SUBMISSION TO DEPARTMENT OF PLANNING

Application No MP10_0057
Location 132-138 Killeaton St, St Ives
Proponent Karimbla Properties (No.4) Pty Ltd
Council area Ku-ring-gai Council

SUBMISSION

SITE SECTION C-C
SCALE 1:200

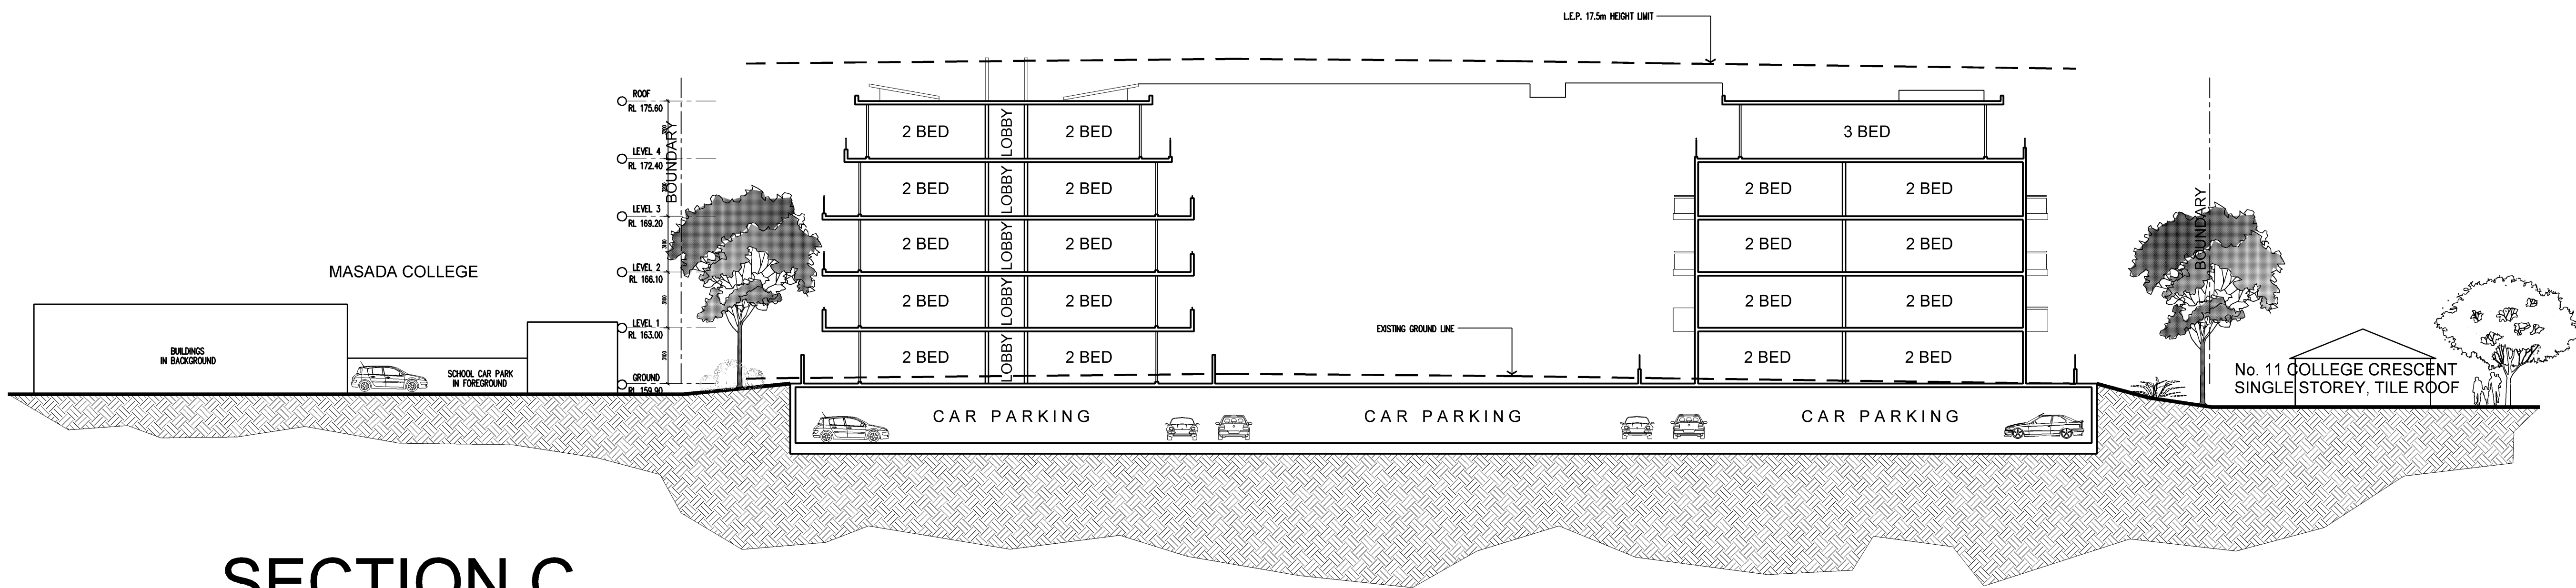
26. The EA does not contain a site section prepared by the Applicant which show the positioning of Building E to my property at 15 College Crescent, However the Applicant's drawing Site Section C-C [DA-47] is a site section showing the relative elevation of Building E and the property at 11 College Crescent, being my northern next door neighbour in College Crescent (there being no 13 College Crescent). The Applicant's Site Section C-C drawing does show the landfall from the Development Site to the College Crescent properties which are at a considerable lower level than the Development Site. It is clear from the Applicant's Side Section C-C drawing that the top of the roof of 11 College Crescent is at the same level as the top of the ground floor apartment in Building E. Therefore the remaining 4 levels of Building E are higher than the top of the roof of 11 College Crescent and have clear and uninterrupted lines of sight into each of the College Crescent properties. As my property at 15 College Crescent is at a level even lower than 11 College Crescent in comparison to the Development Site, the impact of Building E on my property at 15 College Crescent is even greater than that shown in the Applicant's Site Section C-C drawing.

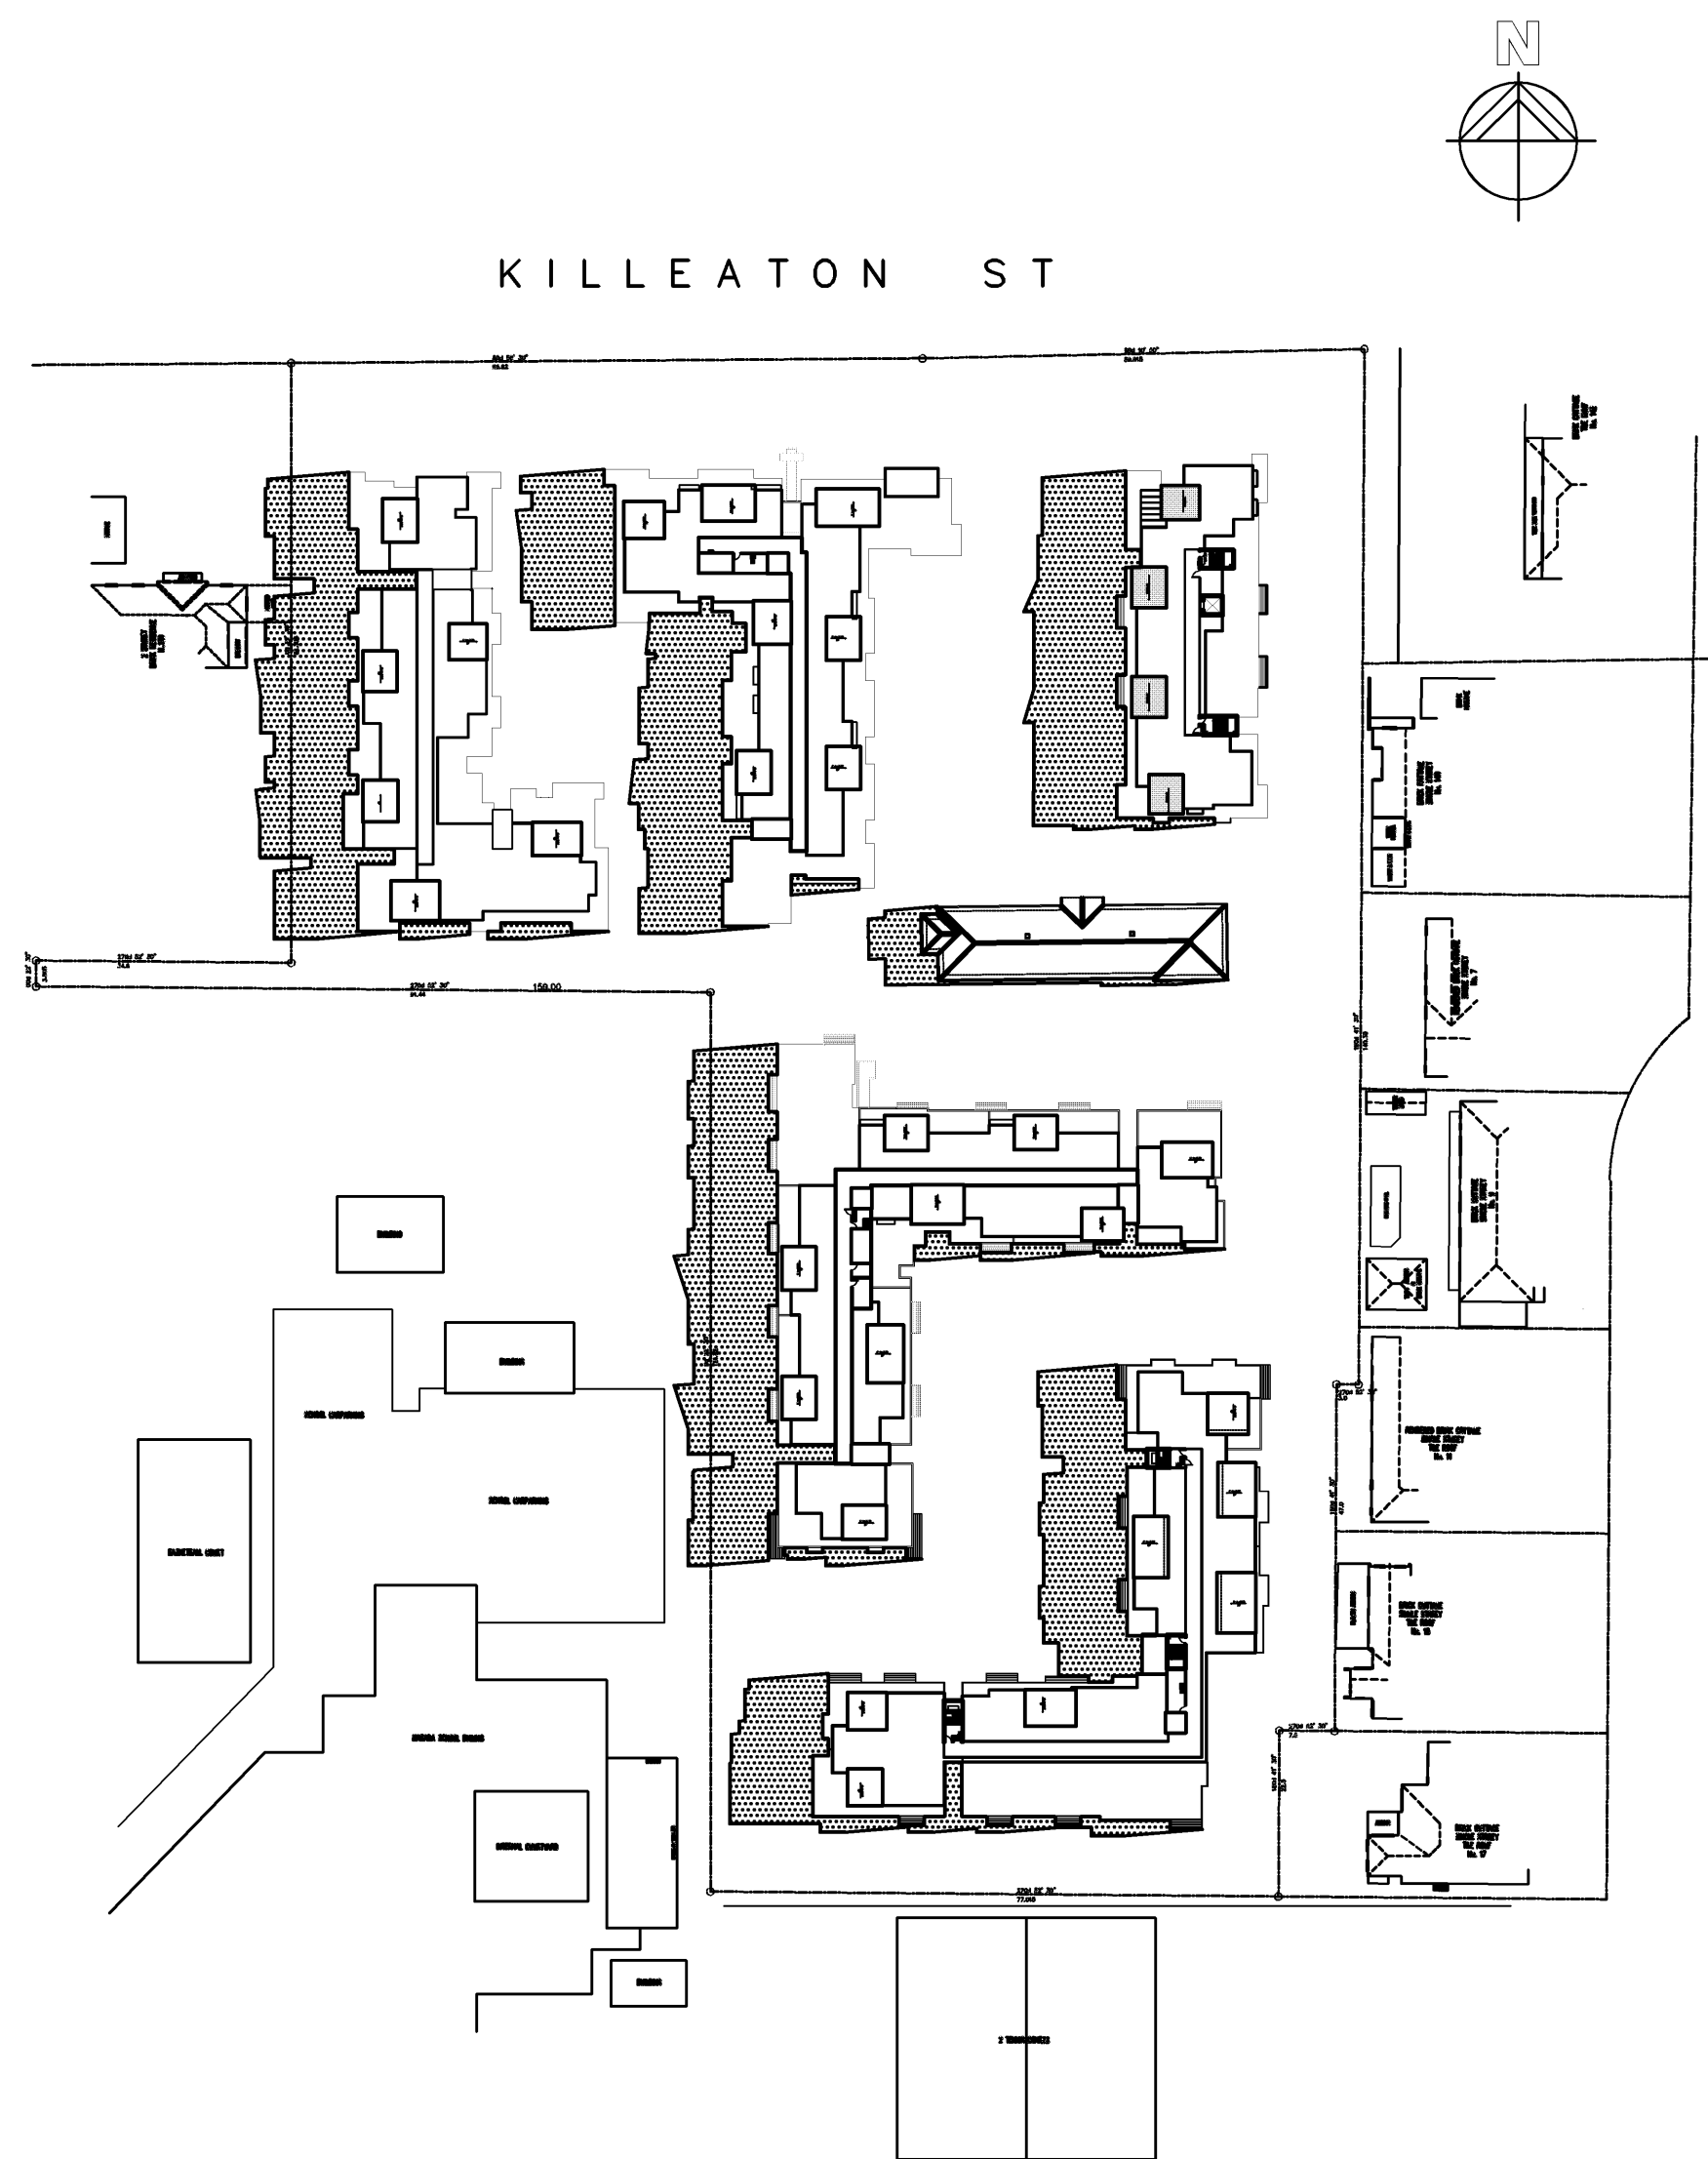
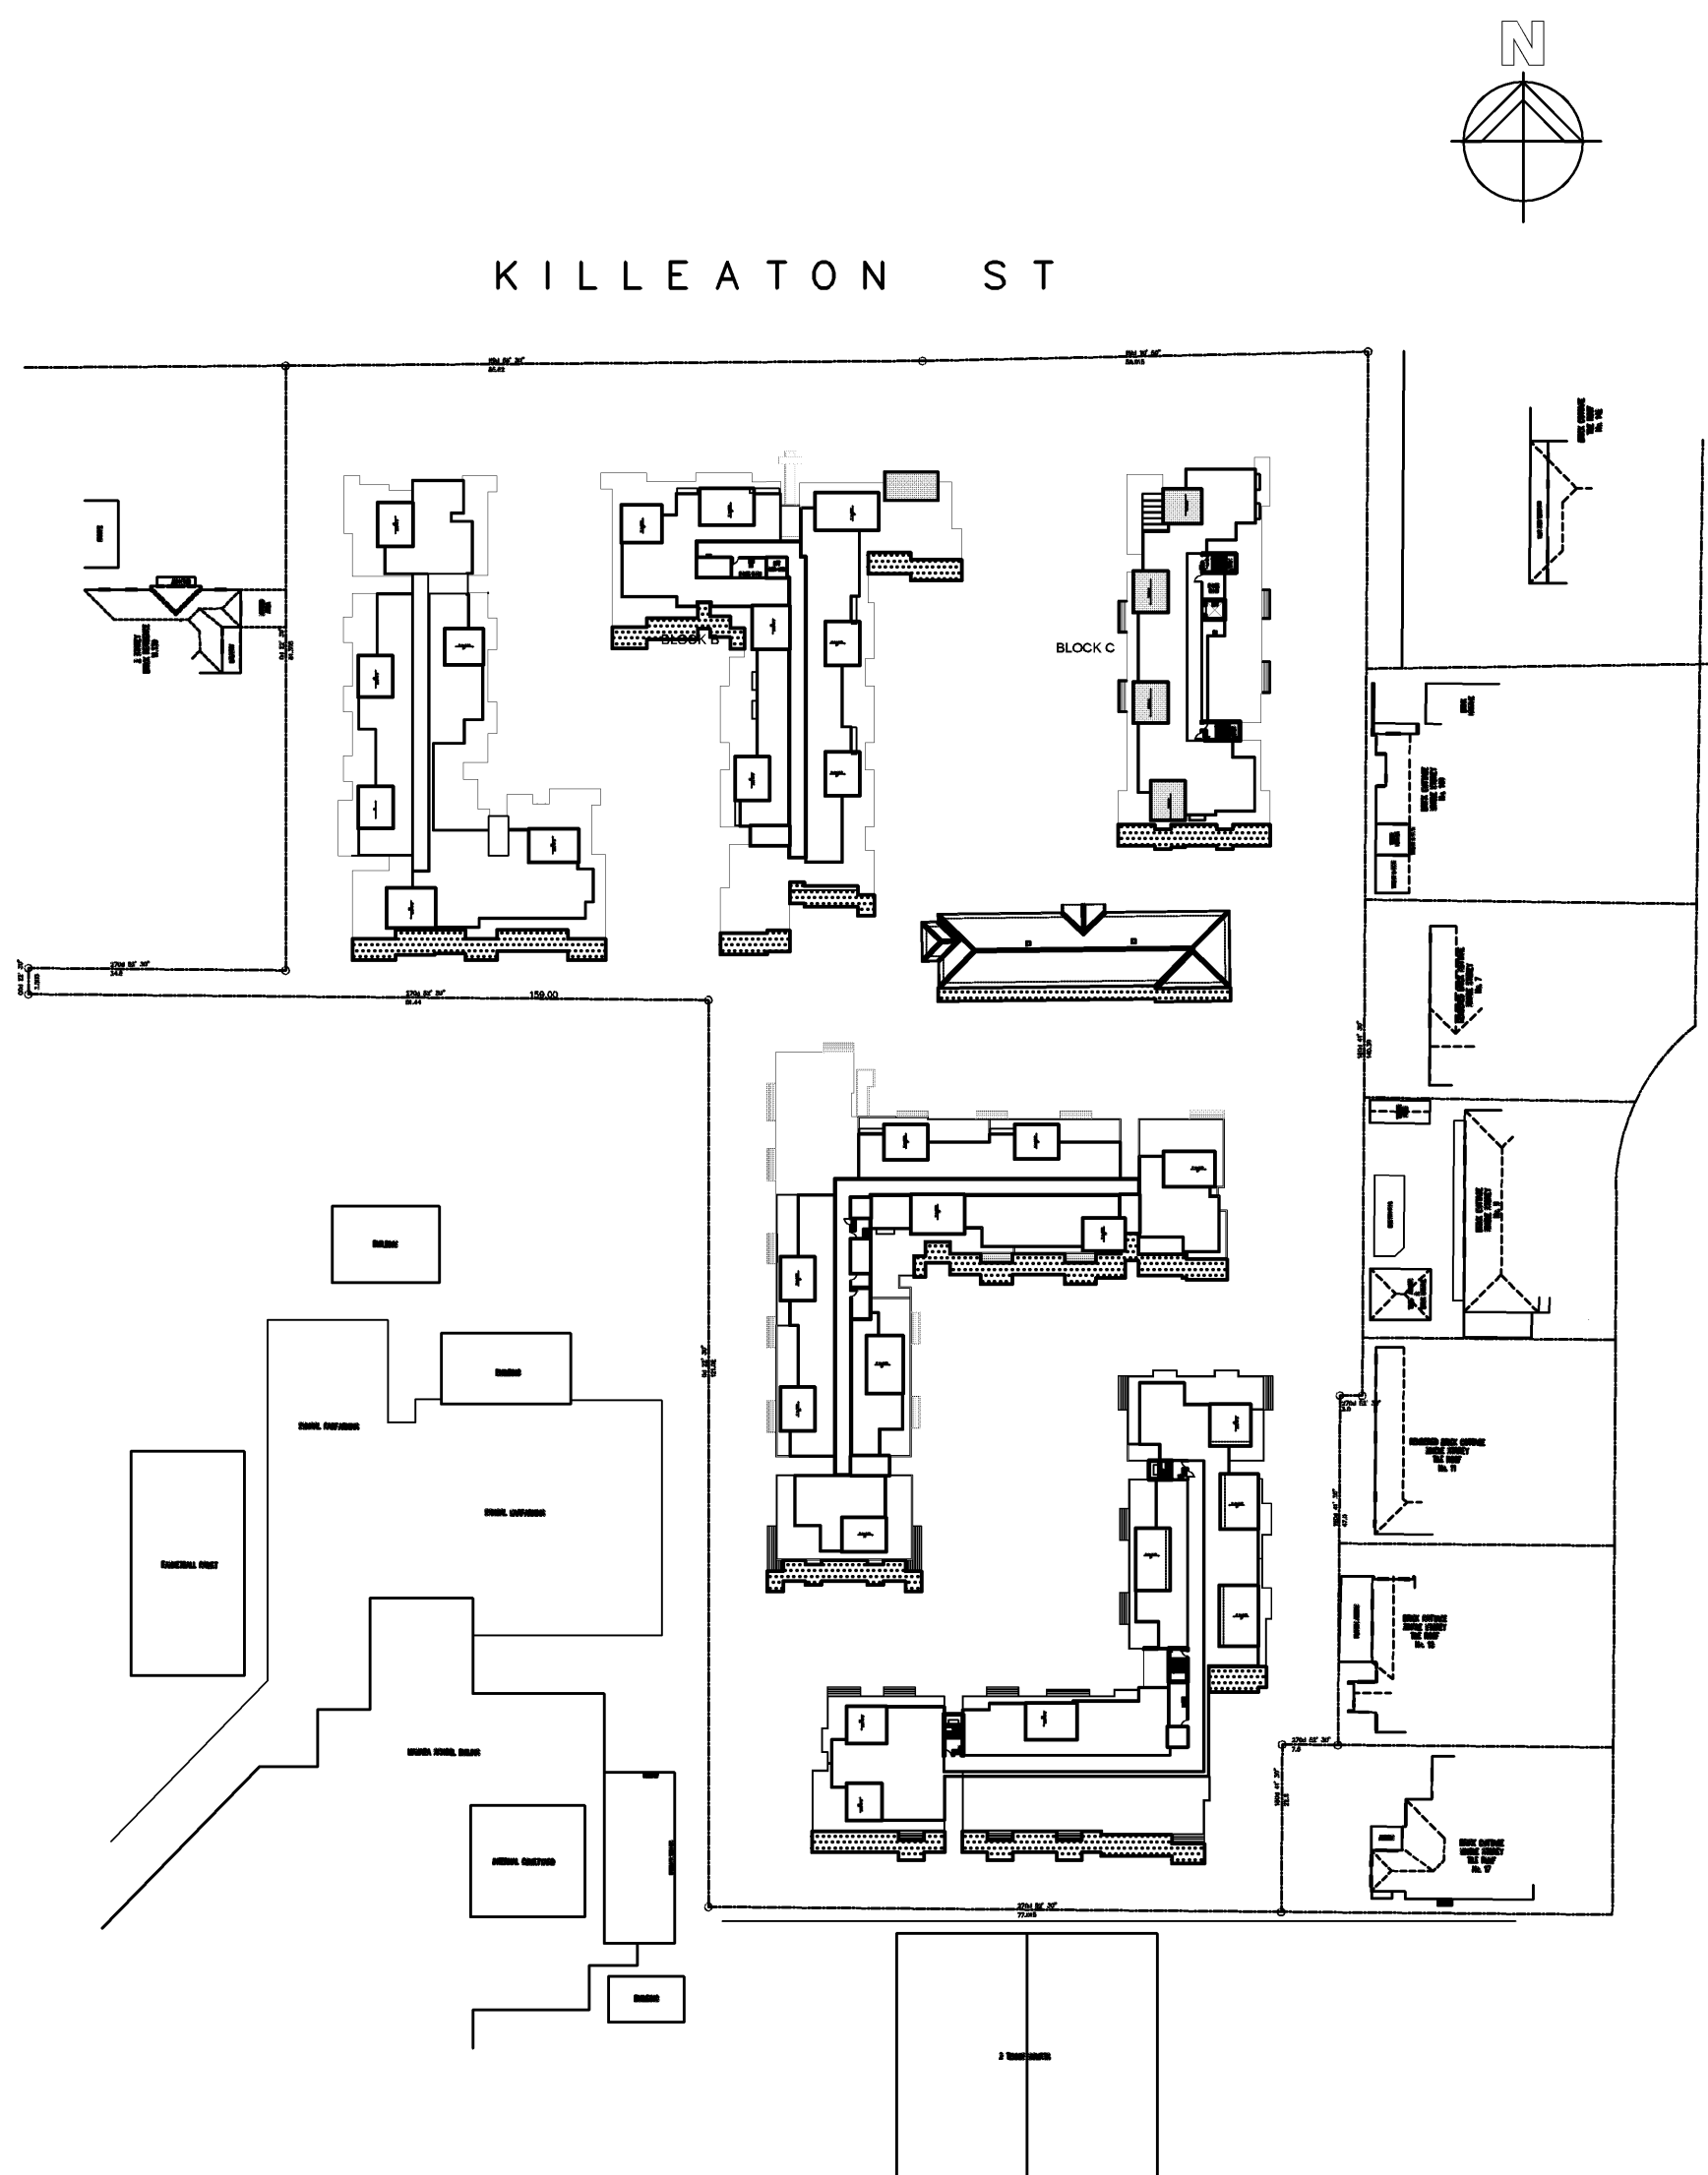
37. The shadow diagrams prepared by Meriton which are at Annexure 4 to the EA (Shadow Diagrams -1 [DA-70], Shadow Diagrams -2 [DA-71], Shadow Diagrams -3 [DA-72], Shadow Diagrams -4 [DA-73]), probably better reflect the impact on solar access and overshadowing that the proposed development will have on my house at 15 College Crescent, although it is still unclear whether even those diagrams take into account the natural relative topography of the Development Site and the College Street properties and therefore even those shadow diagrams probably understate the real impact that Building E will have on solar access and overshadowing on my house at 15 College Crescent. It is clear even from these Meriton Shadow Diagrams that by 3pm (and probably well before that time) on 21 June the whole of my house at 15 College Crescent will be overshadowed and have no solar access at all to the winter sun.

38. It is also clear from the Meriton Shadow diagrams, that in order to minimise the adverse impact on solar access and overshadowing, what is required is that Building E be repositioned at least 24 metres from my house. It is instructive that for the purpose of providing adequate solar access to the apartments in the development the Applicant has provided for a distance of about 24 metres between Building D and Building E. Therefore the Applicant is achieving an acceptable solar and overshadowing environment for the apartment in the development but at the expense of the amenity of my house at 15 College Crescent.
